From: Nina Sidhu
Sent: 06 November 2018 14:38
To: Planning.Responses
Cc: Anita Gardner
Subject: FG/159/18/PL Bluebird Cafe

Nina Sidhu
Senior Environmental Health Officer

01  
2002  
PROPOSED GROUND FLOOR PLAN  
Scale: 1:100

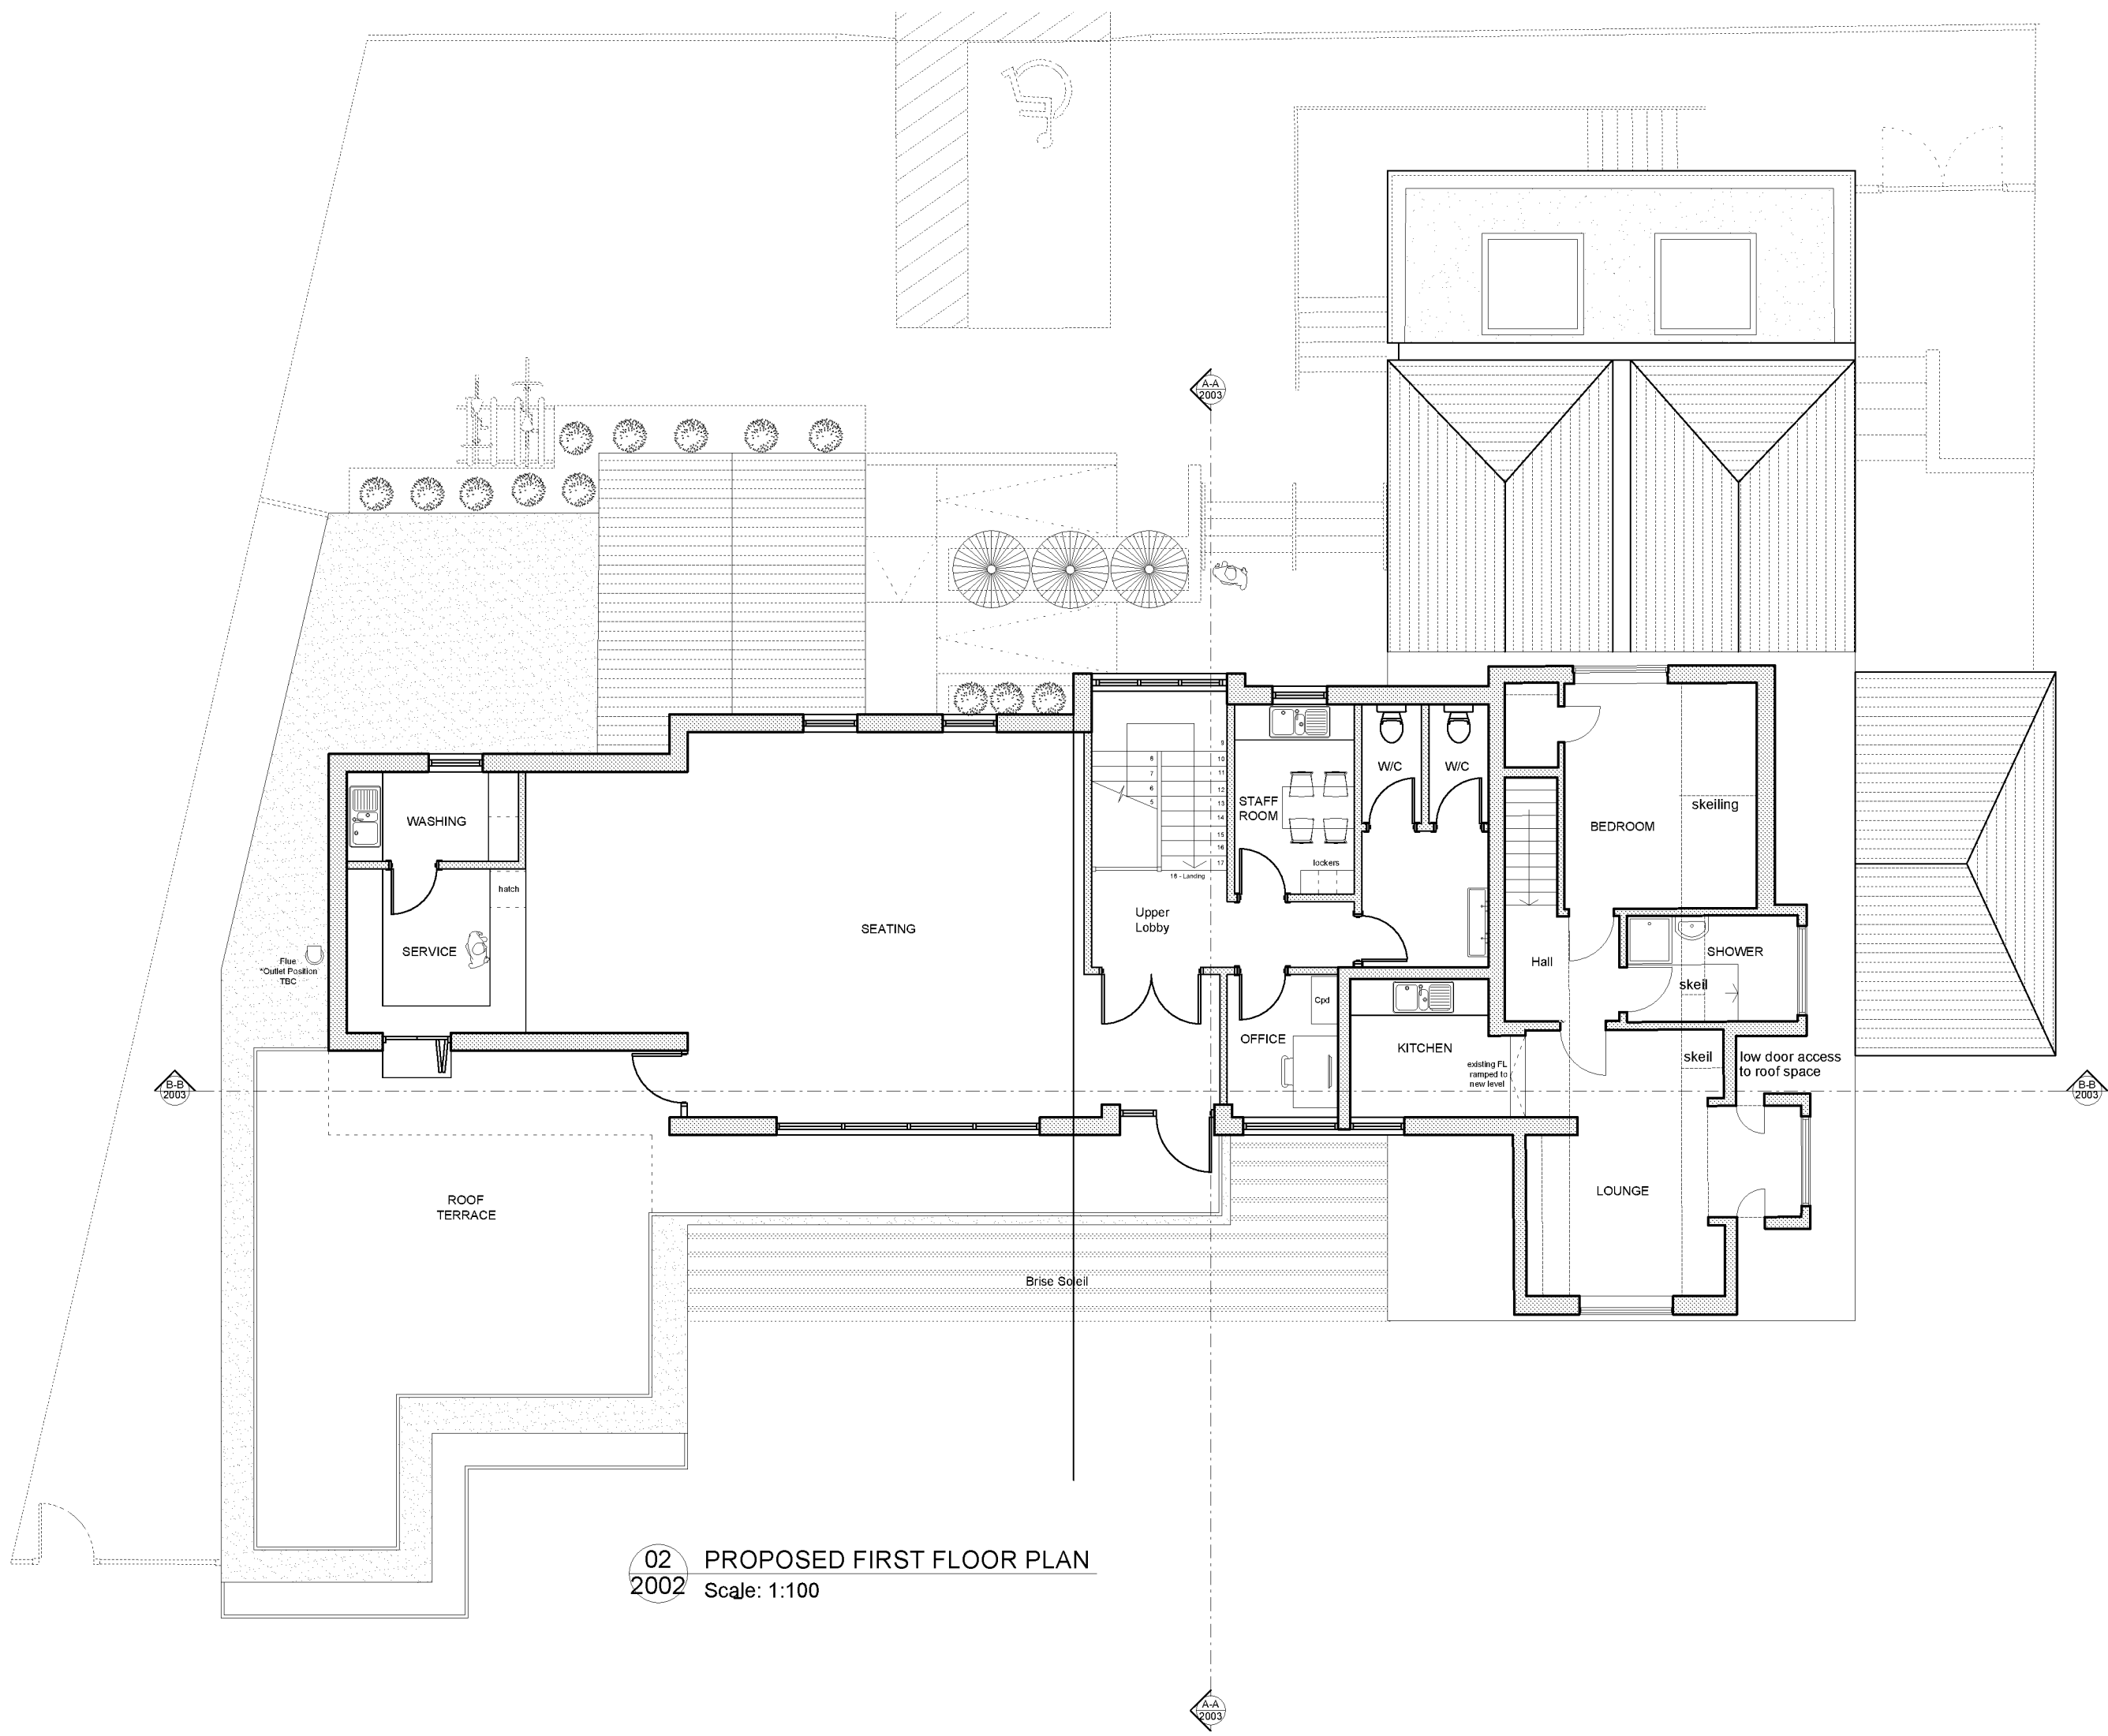
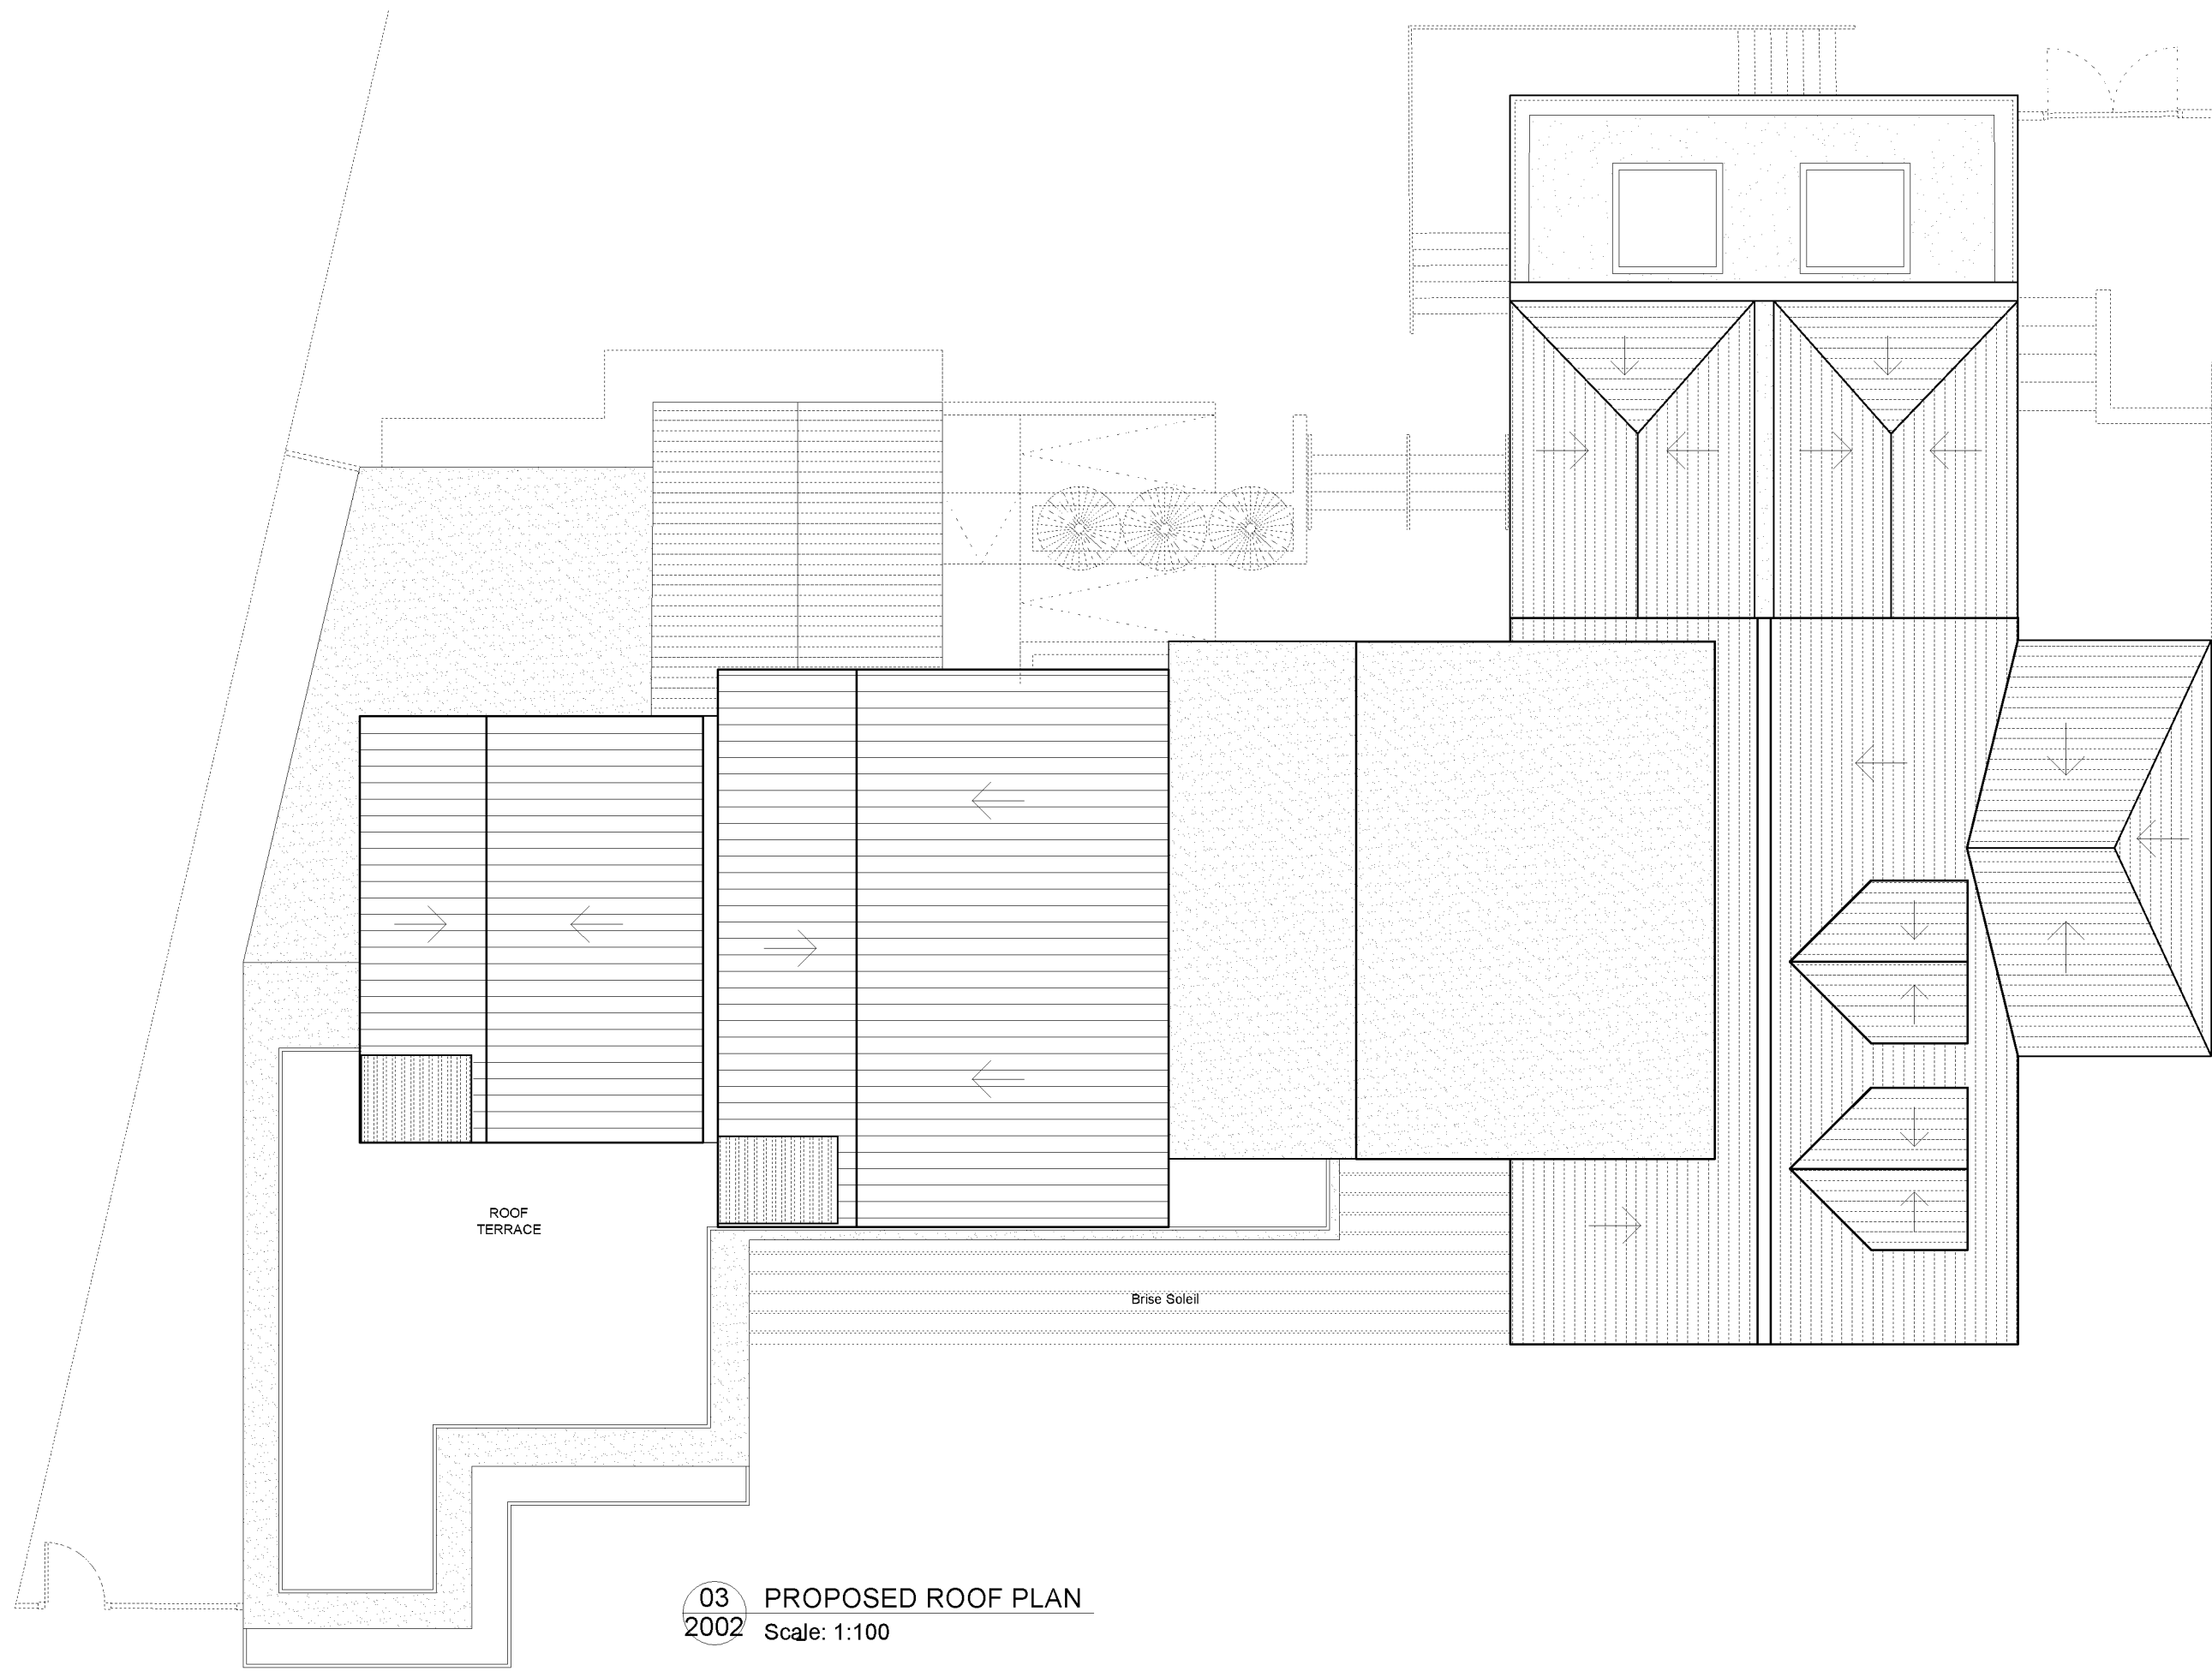
- 2) Sanitary provision: If the total number of covers is 235 the sanitary provision is insufficient and staff do not appear to have been considered. Please refer to Arun's Sanitary Provision Requirements document:
<https://www.arun.gov.uk/download.cfm?doc=docm93ijm4n11788.pdf&ver=11779>

Appendix 01 - Seating Layout

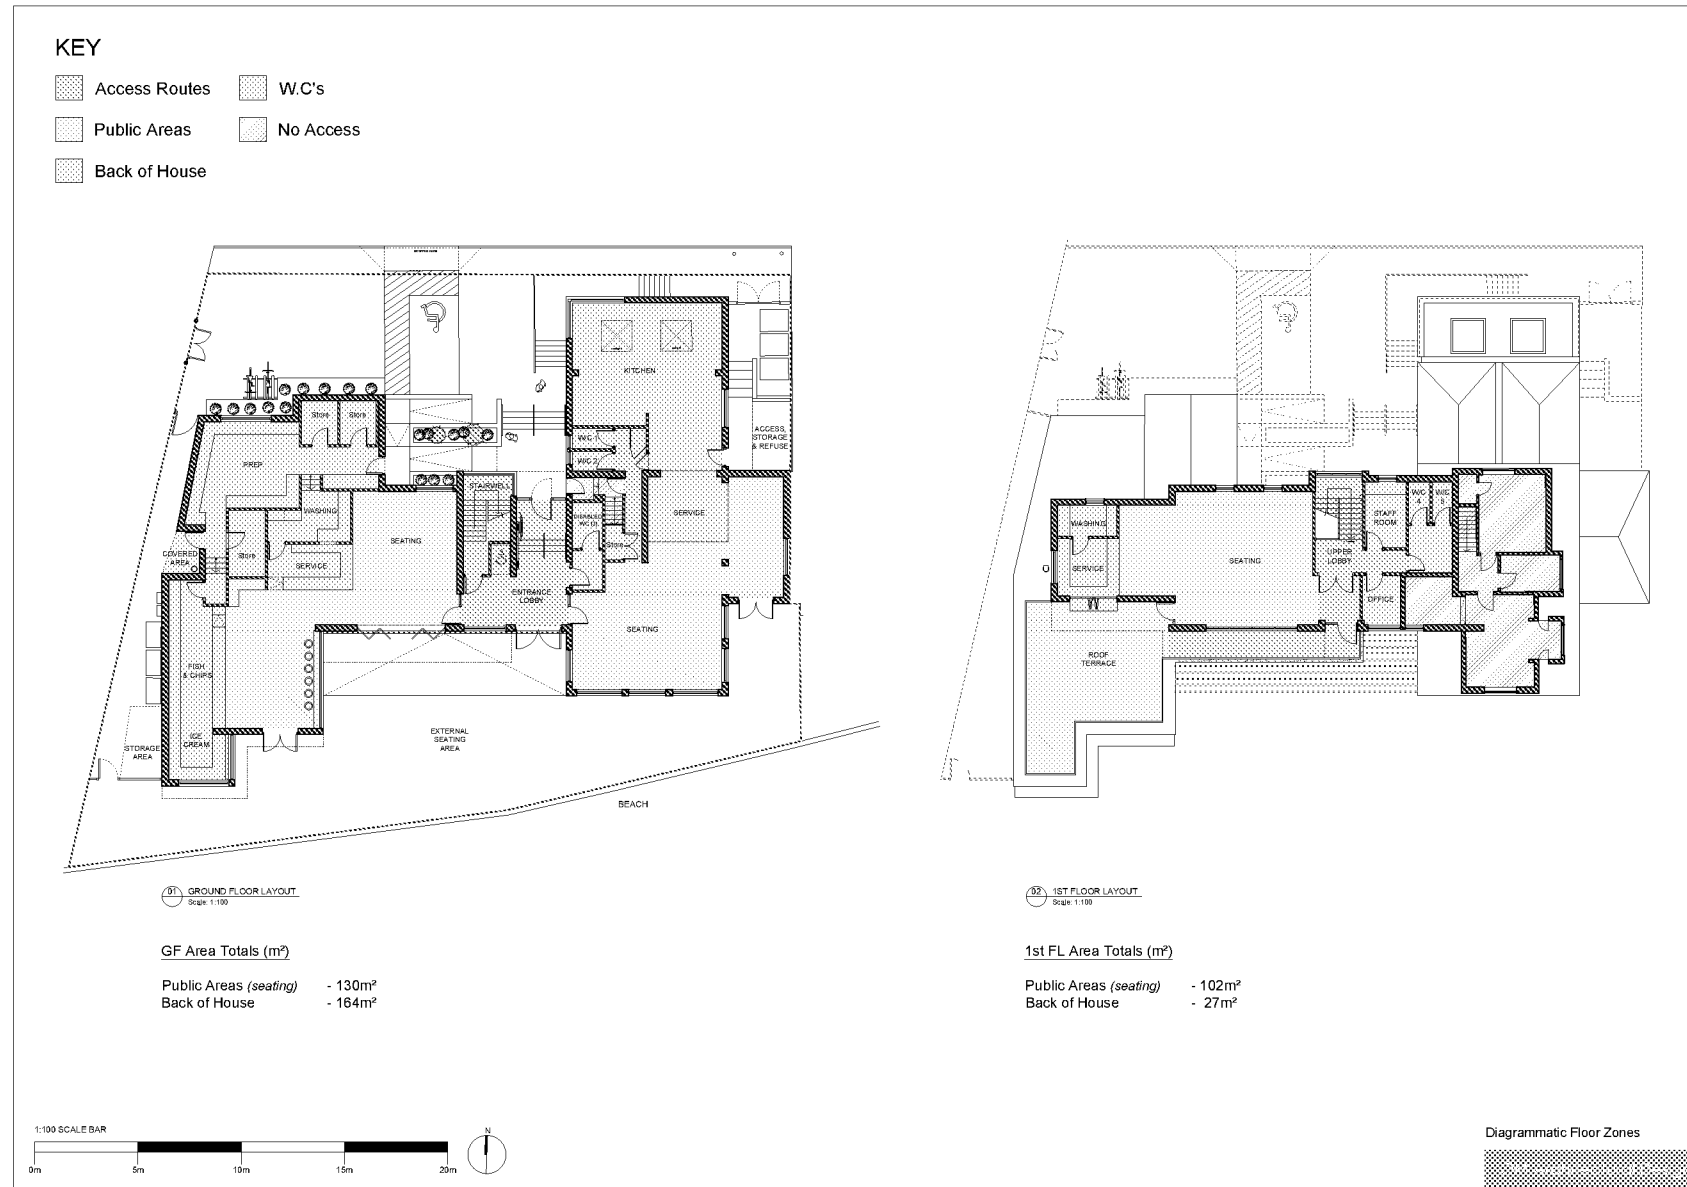
- 1) I am unclear as the exact number of covers proposed. Is the total number of covers 235? There is slightly conflicting information in the application documents and I would just like to clarify the exact numbers.
